Architectura Design
463 Chichester Road
Bognor Regis
PO21 5EB

Application for Planning Permission

Development: Change of use from existing open barn to 1 No. dwelling (C3 Dwelling House), refurbishment & single storey extension to North elevation (renewal of permission Y/60/16/PL, amended with Y/53/19/NMA).
Location: North Barn Hoe Lane Flansham PO22 8NT

Drawing P01a November 2020 Scale 1:100 @ A3
Proposed Drawing - Floor Plan, Roof Plan & Elevations

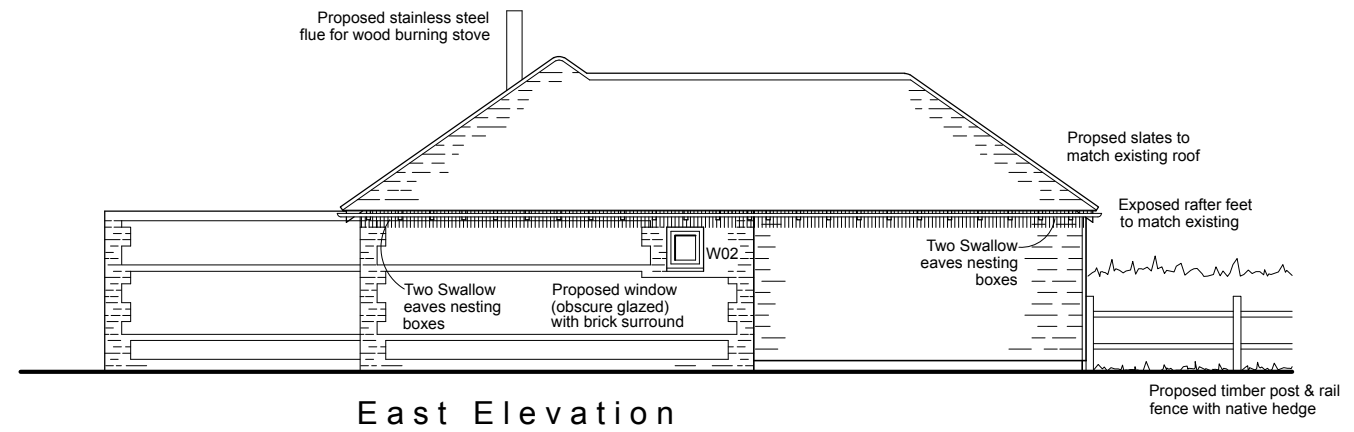
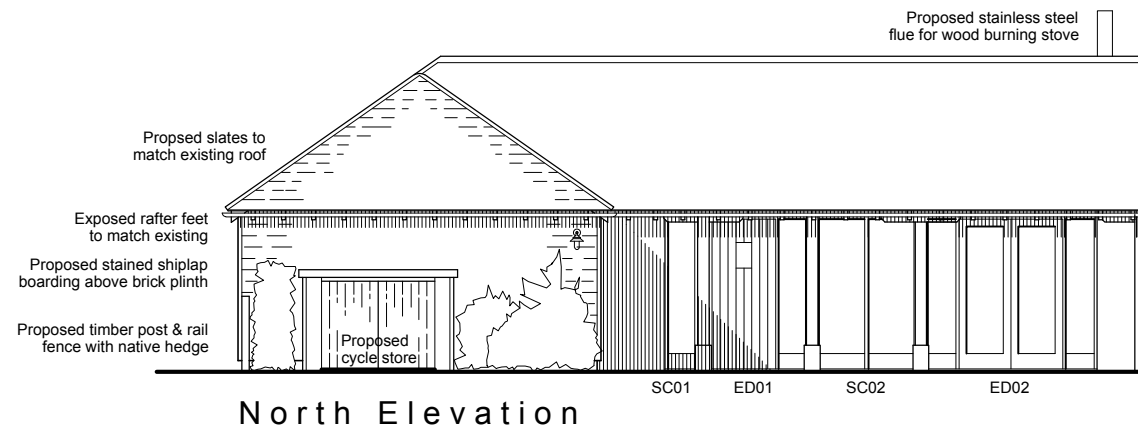
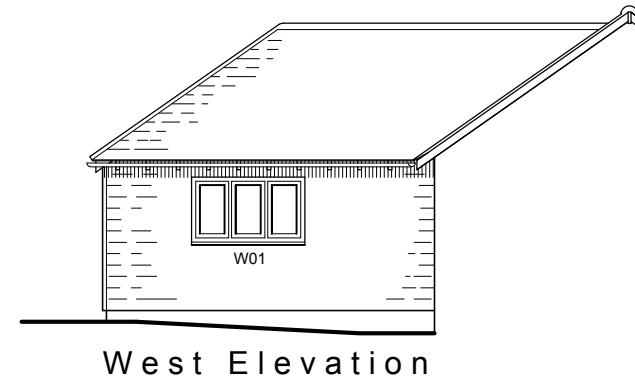
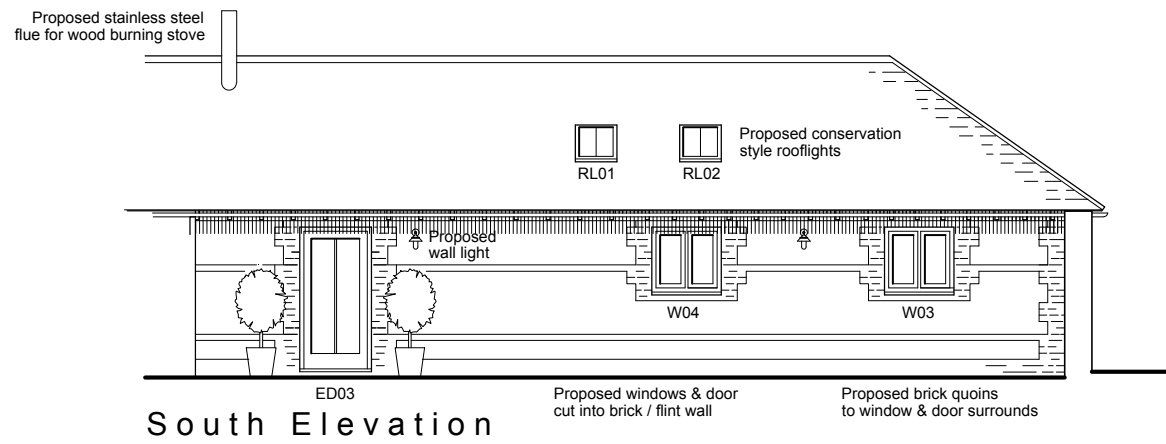
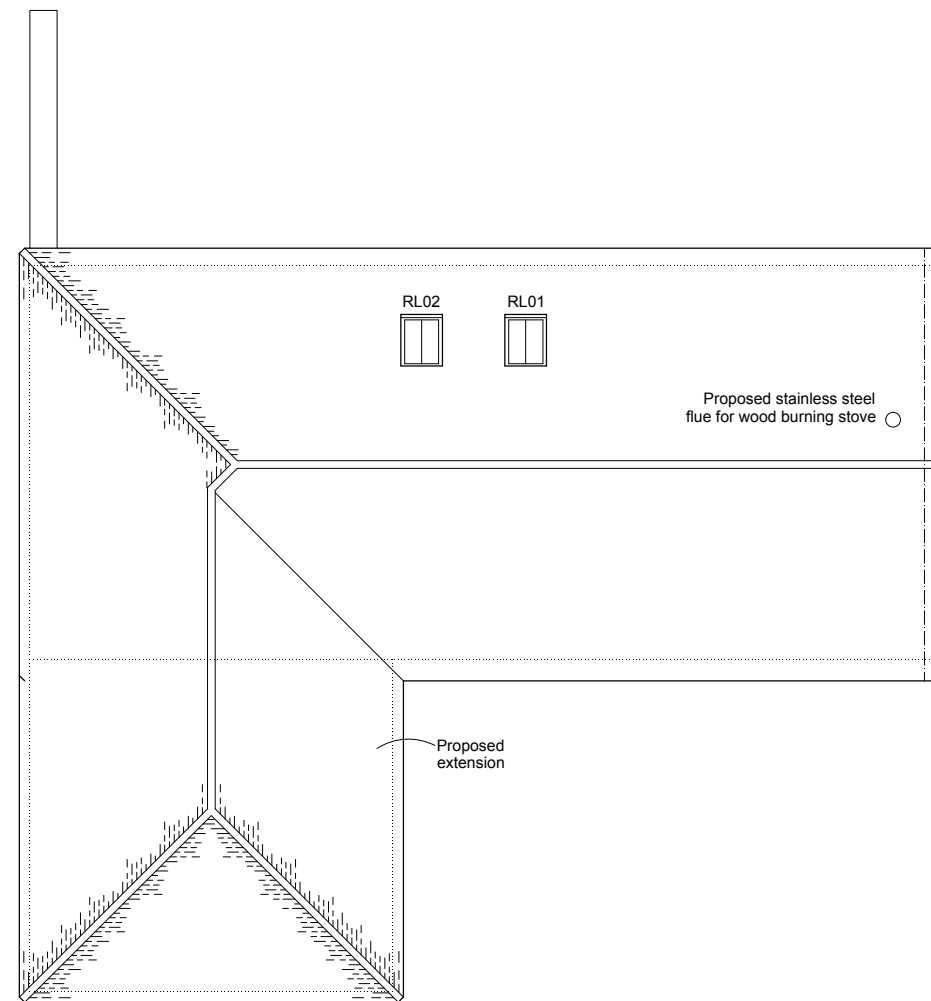
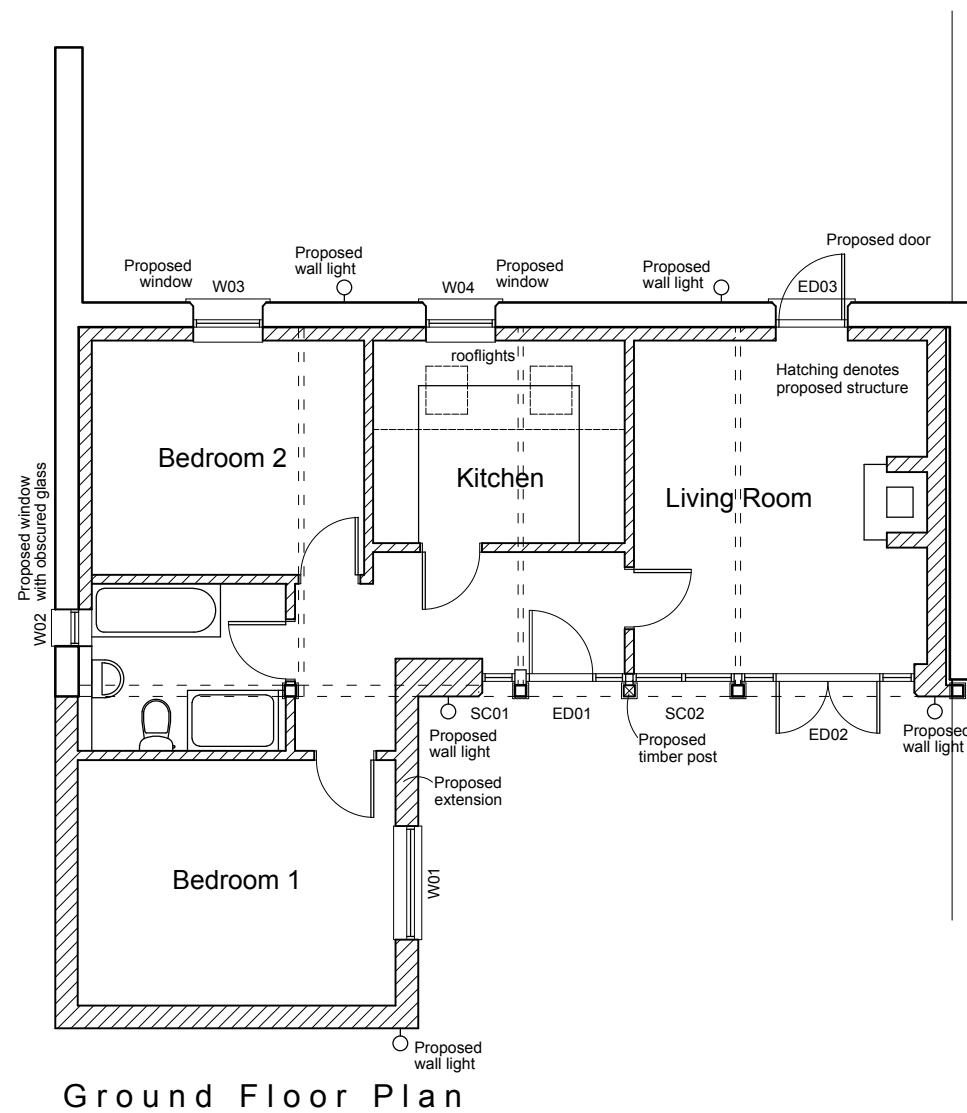
On plan P01, two north elevations have been labelled. Please amend accordingly.
